Application by RWE Renewables UK Solar and Storage Limited for Tween Bridge Solar Farm Project
The Examining Authority's written questions and requests for information (ExQ1): Issued on 24 April 2026
Responses are due by deadline 2: 19 May 2026

Please find below answers to the Examining Authority's written questions from the Environment Agency (EA) [ref no. F1C2DDF91].

THE EXACT ARRANGEMENT WITHIN THE OVERALL SITE LAYOUT IS TBC AT THE NEXT STAGE OF DESIGN.

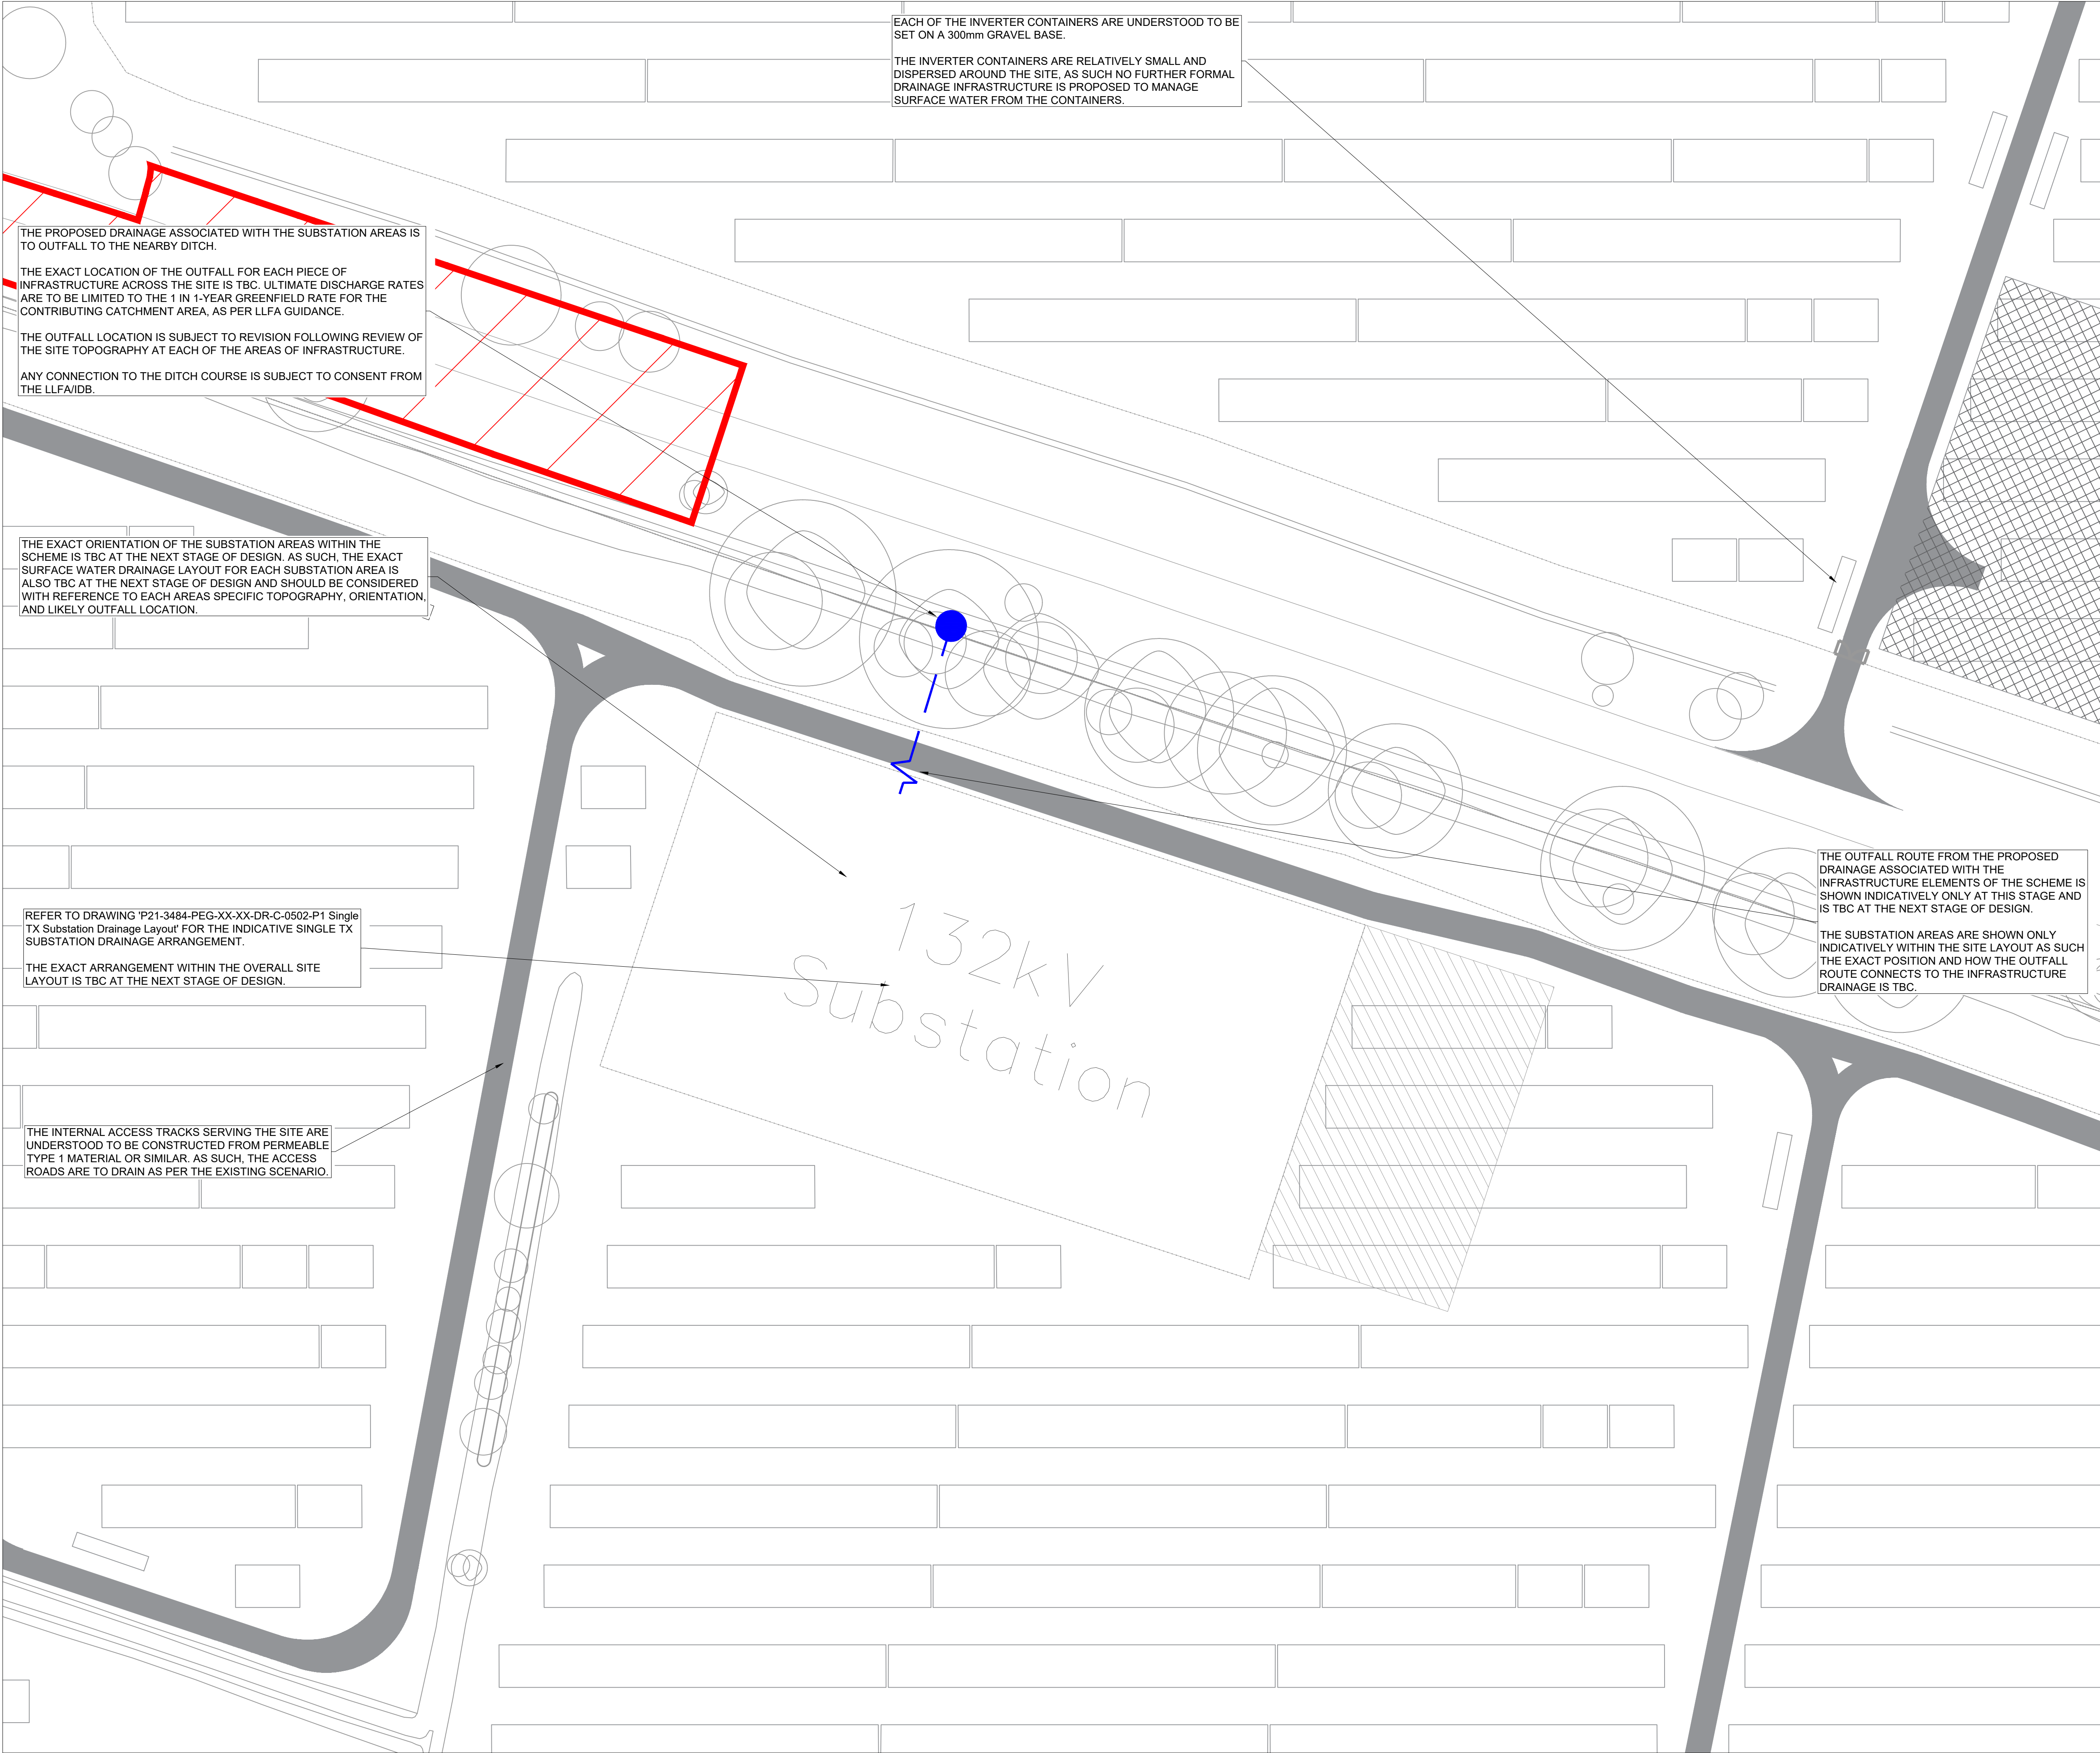
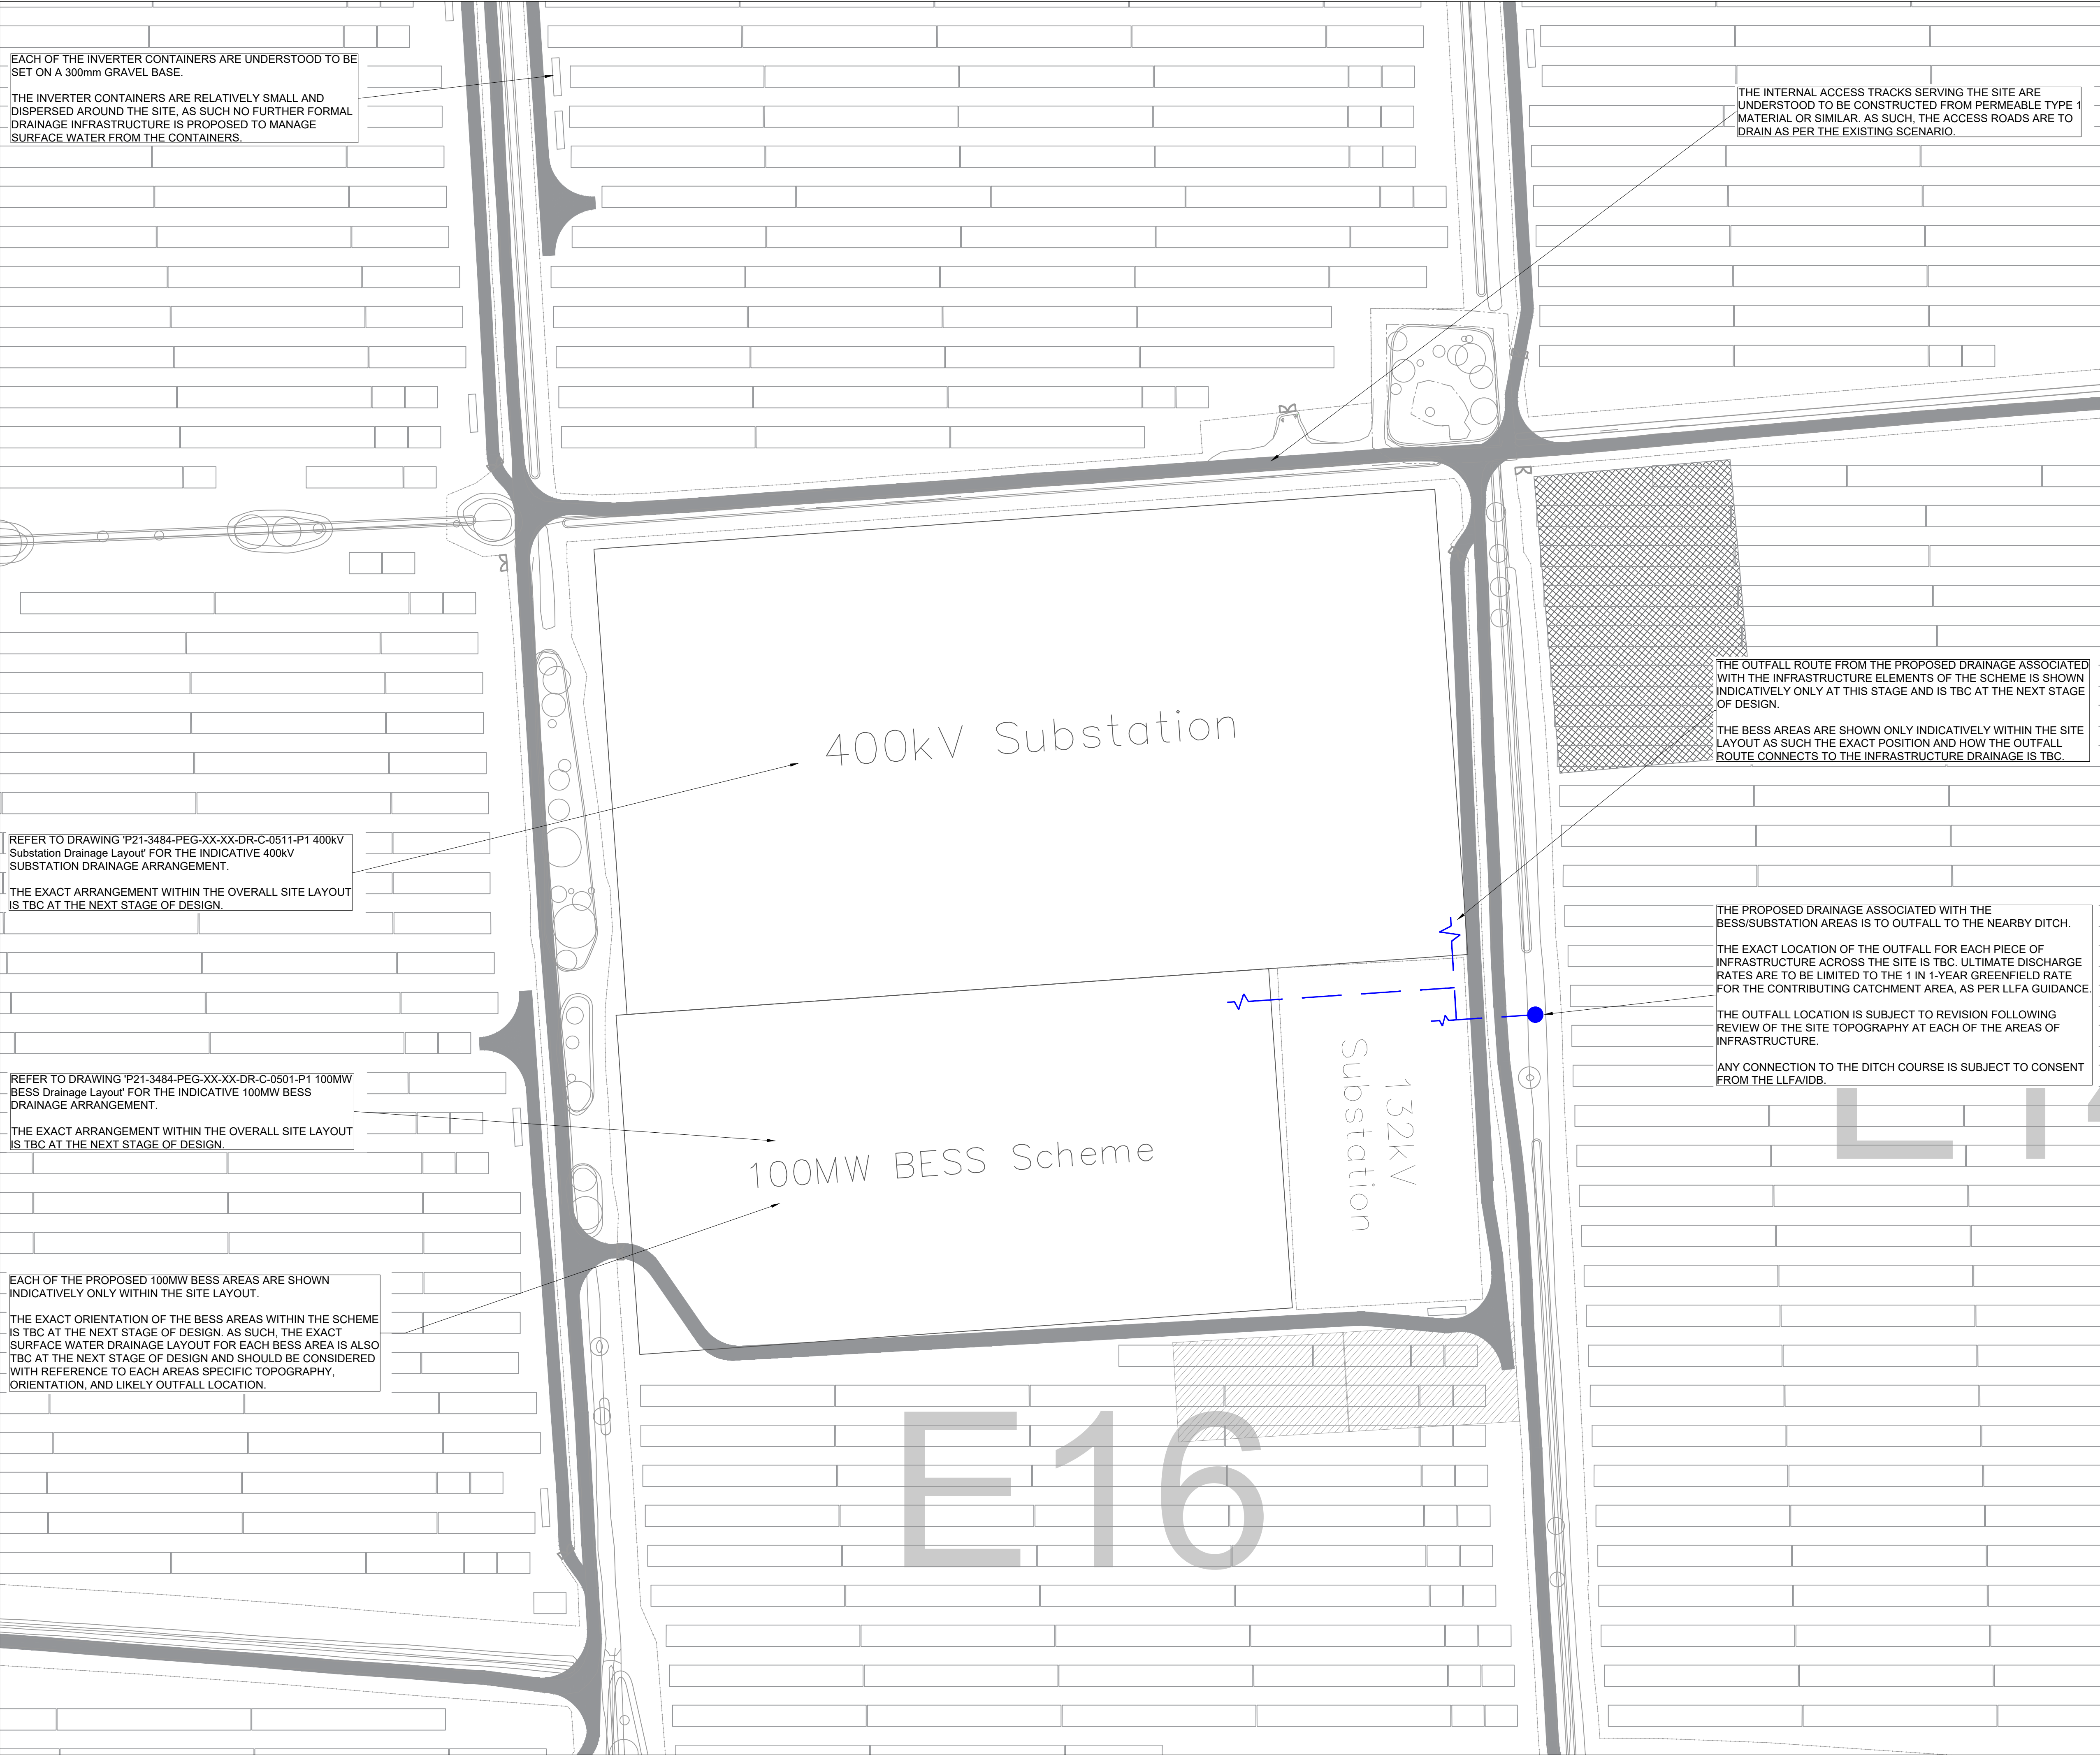
Ref No.	Question	EA response
Q7.0.22	<p>Outline Surface Water Drainage Strategy</p> <p>Could the EA and Council's please confirm the acceptability or otherwise (in principle) of the outline surface water drainage strategy at FRA section 7 and appendices I and J [APP-108-109]?</p>	<p>The EA can confirm that (in principle) it considers the outline surface water drainage strategy is acceptable. We will need to have further discussions with the applicant at the detailed design stage to confirm and agree the strategy in relation to the protection of Controlled Waters. We are satisfied that our inclusion as a specific consultee to Requirement 7 (Battery safety management plan) and Requirement 11 (Surface and foul water drainage) will enable us to do this.</p>
Q7.0.31	<p>Operational reason for locating in flood zone 3b</p> <p>NPS EN-1 paragraph 5.8.41 states in full: <i>“Energy projects should not normally be consented within Flood Zone 3b , or Zone C2 in Wales, or on land expected to fall within these zones within its predicted lifetime. This may also apply where land is subject to other sources of flooding (for example surface water). However, where essential energy infrastructure has to be located in such areas, for operational reasons, they should only be consented if the development will not result in a net loss of floodplain storage, and will not impede water flows.”</i></p> <p>Please could the applicant explain whether there are any operational reasons why this development needs to be located within flood zone 3b?</p>	<p>The EA can confirm that the project will not impact on the available flood storage capacity within Flood Zone 3b. The EA holds no view on the operational reasons why the development needs to be located within Flood Zone 3b.</p>
